Director, Transport Assessments Planning services
Department of planning , industry and environment
GPO box 39
Sydney NSW 2001
Re application : SSI 7485

I write regarding the proposed modification to the M4_M5 Link, MOD 2. The Crescent overpass and changes to pedestrian infrastructure in north Annandale, Rozelle and Rozelle Bay foreshore area.

Figure 4-2 Pedestrian and cyclist bridge infrastructure options

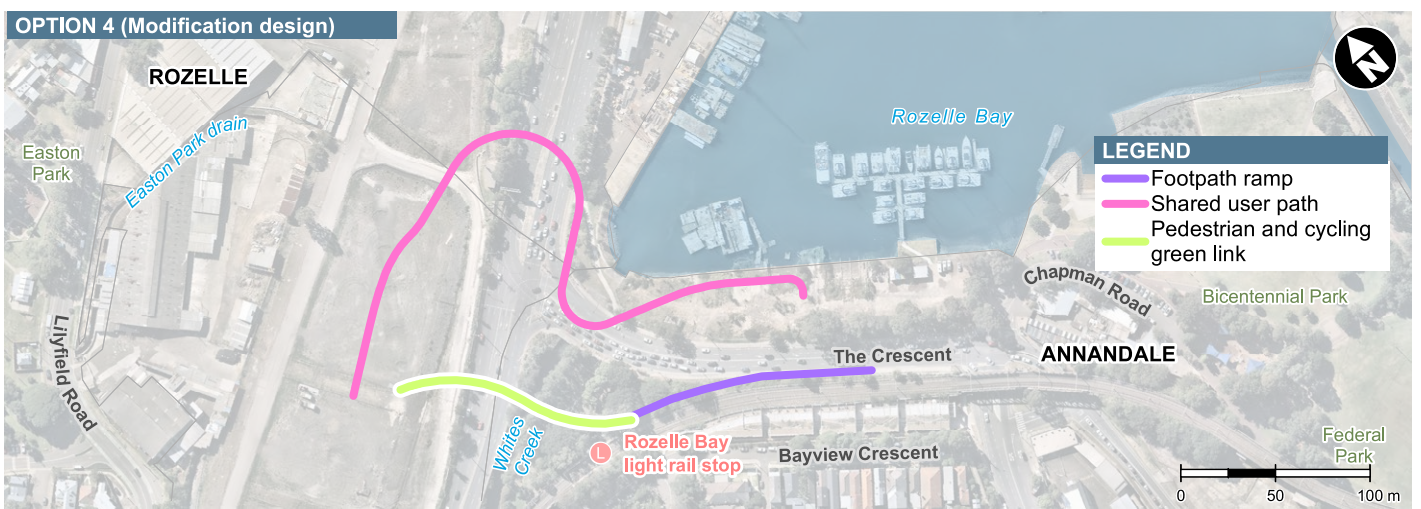
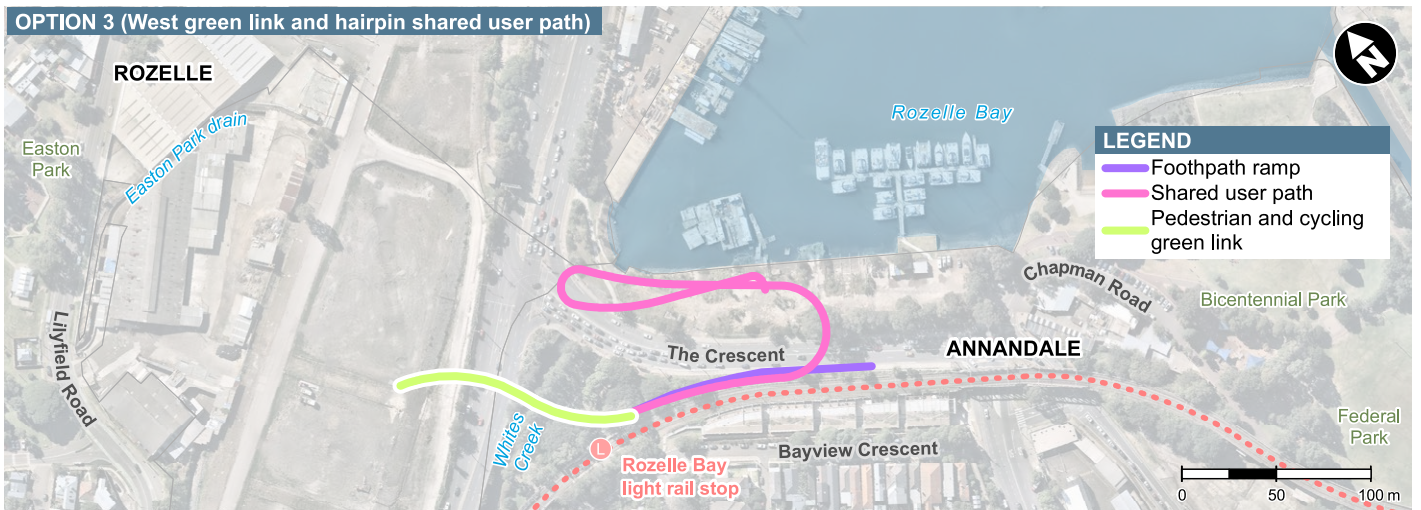
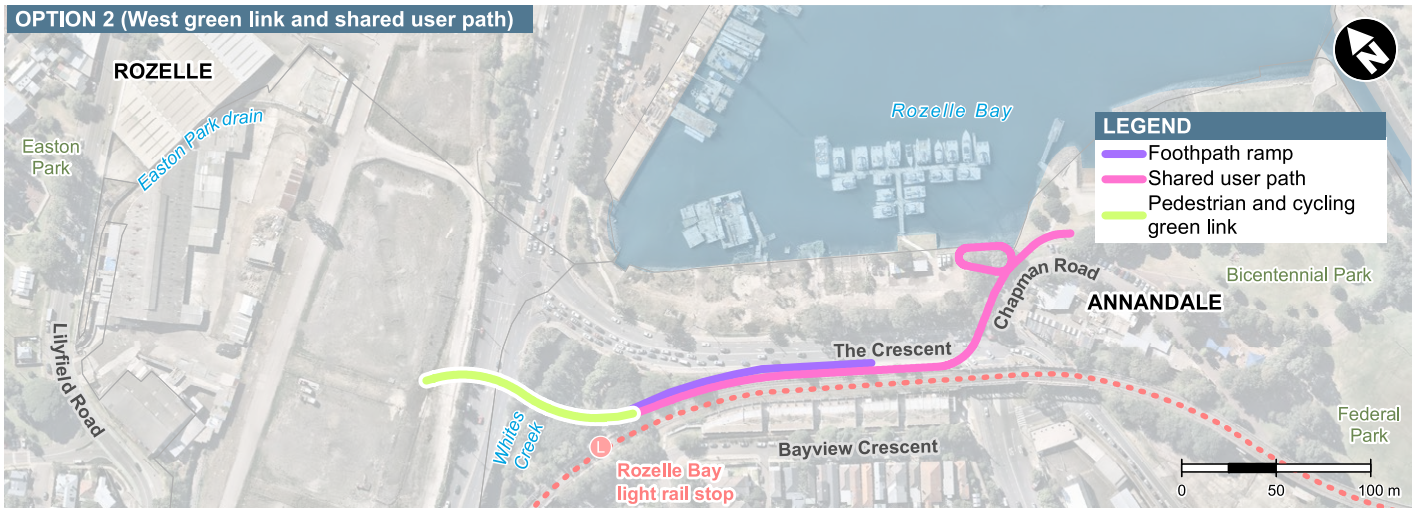
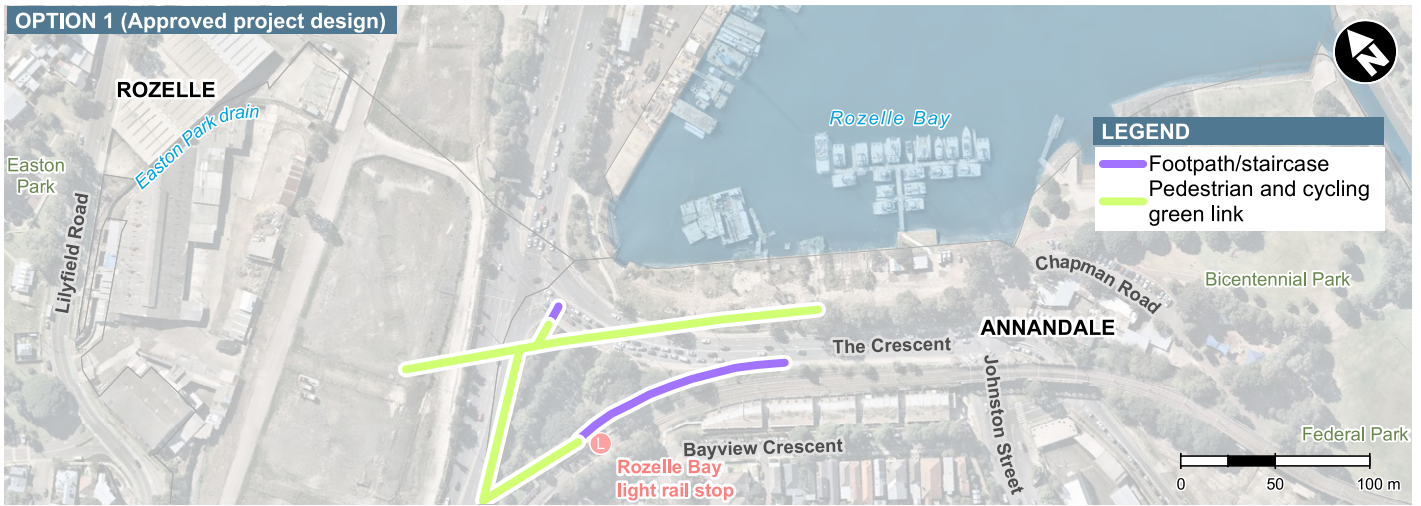
I request RMS work with the community to explore alternate design options to the proposed new car overpass design and the changed pedestrian/Cycling links. I am seeking the reinstatement of the safe, direct access from the approved EIS greenlink to create a continuous green open space from the Rozelle rail yards and Annandale to the foreshore. The greenlink is not just a walk way. It maximises safety, and provides much needed open space for the community, now and future.

- *Reinstate the Green link connecting communities and green open space from Rozelle to Bicentennial Park.
- *Relocate and design pedestrian and cyclist connections that are continuous, safe and direct.
- *Design the modification infrastructure and active links in response to the character of the suburbs, the location of the foreshore and its potential future development.
- *Provide pedestrian and cyclist paths that maximise people safety and do not force them onto busier streets, unsafe concrete plazas and caged walkways.
- *Integrate active and direct connections to all active transport - including the future metro west and foreshore ferry.

Figure 4-4 Elevation: Indicative view of The Crescent overpass

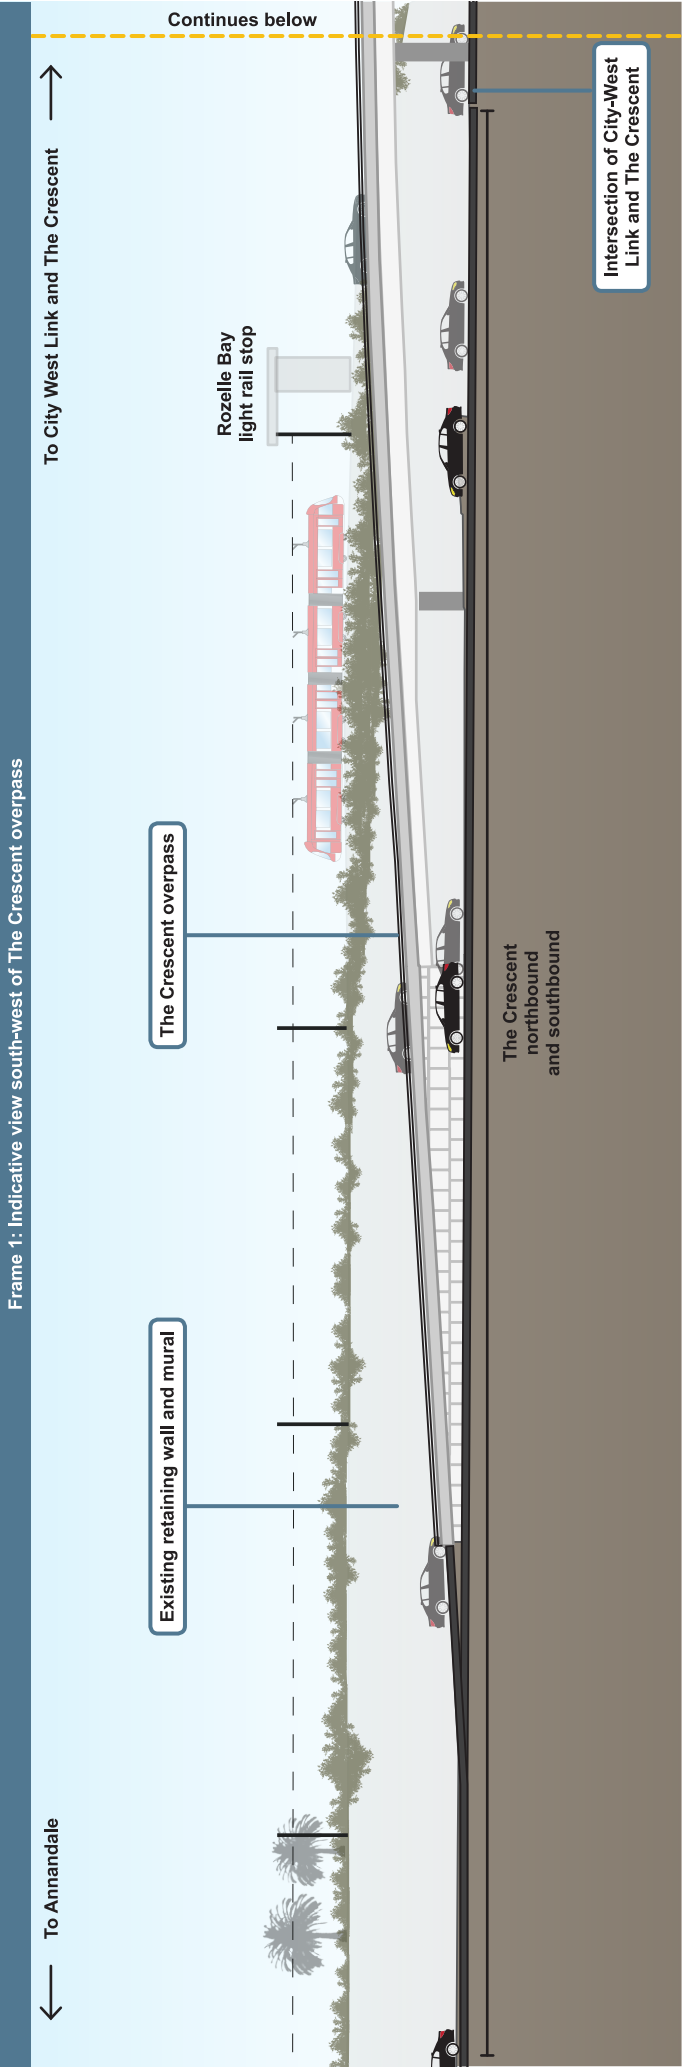
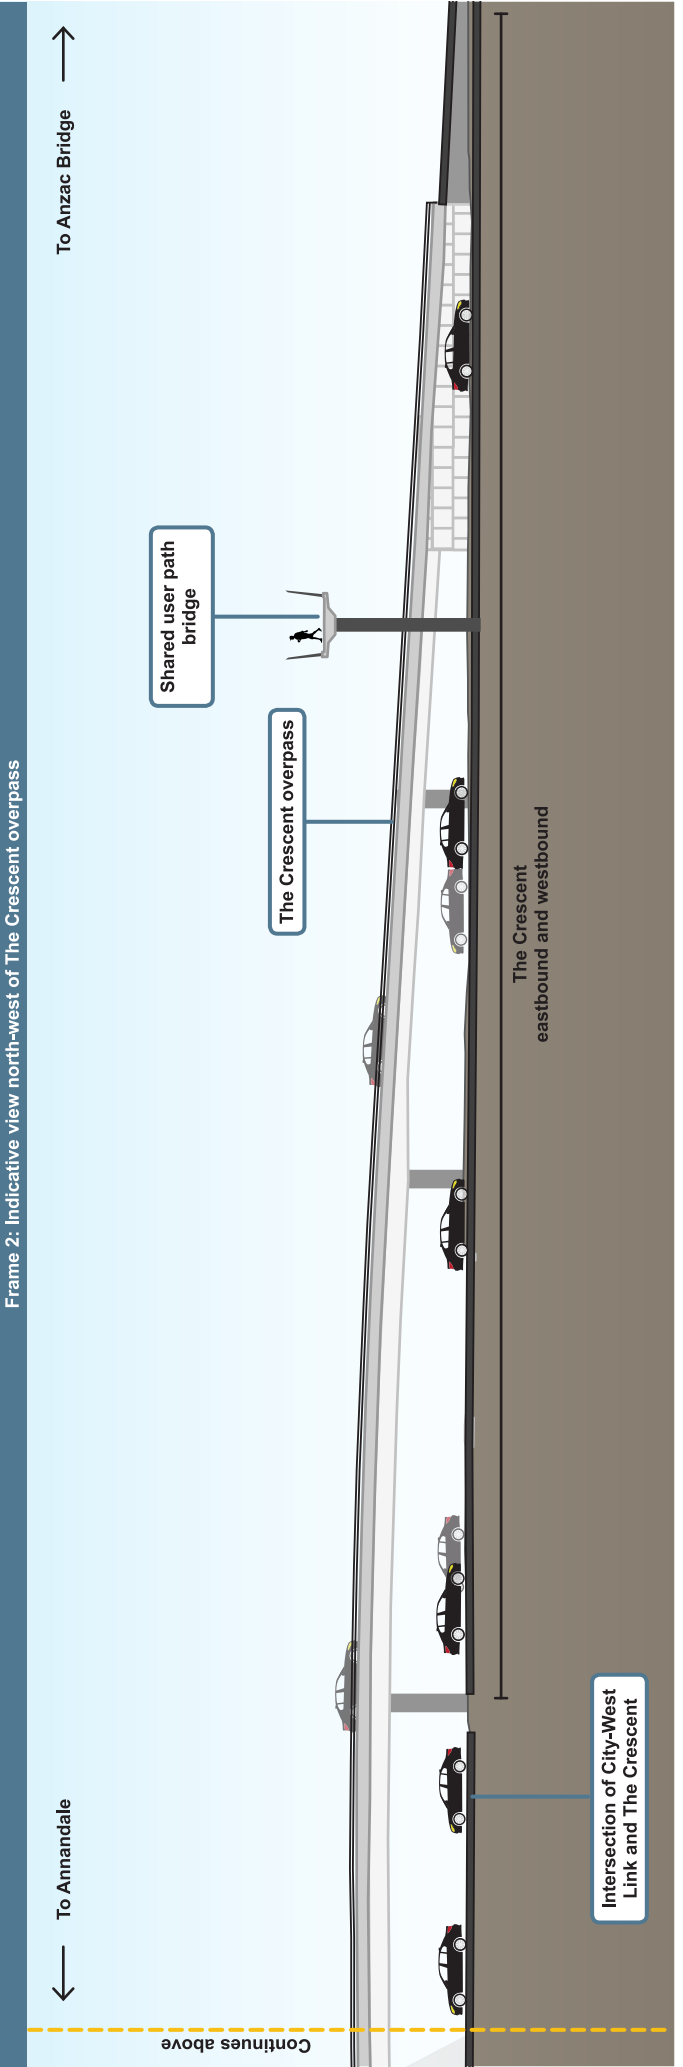
- *Significant reduction of safety for pedestrians and cyclists with removed access over the Crescent to Bicentennial Park and the increased traffic along Johnston Street.
- *Being required to cross 5 sets of lights at the Crescent as my option to reach the foreshore from Annandale and Rozelle.
- *Removal of direct active links to the foreshore, cutting the community off from the area and the proposed revitalisation of the entire Bays Precinct, including linking the Light Rail and Bus stops to a ferry wharf and metro station.
- *Urban and landscape design that is being built before a finalised Masterplan for the area.
- *Traffic changes that limit movements around the suburb and create further congestion in the local streets of Annandale, Forest Lodge and Rozelle with planning to deal with these.

What an absolutely revolting structure, this is ruining the beauty of this suburb, and will drive people to use their cars more instead of walking or cycling. Please go back to your original proposals.
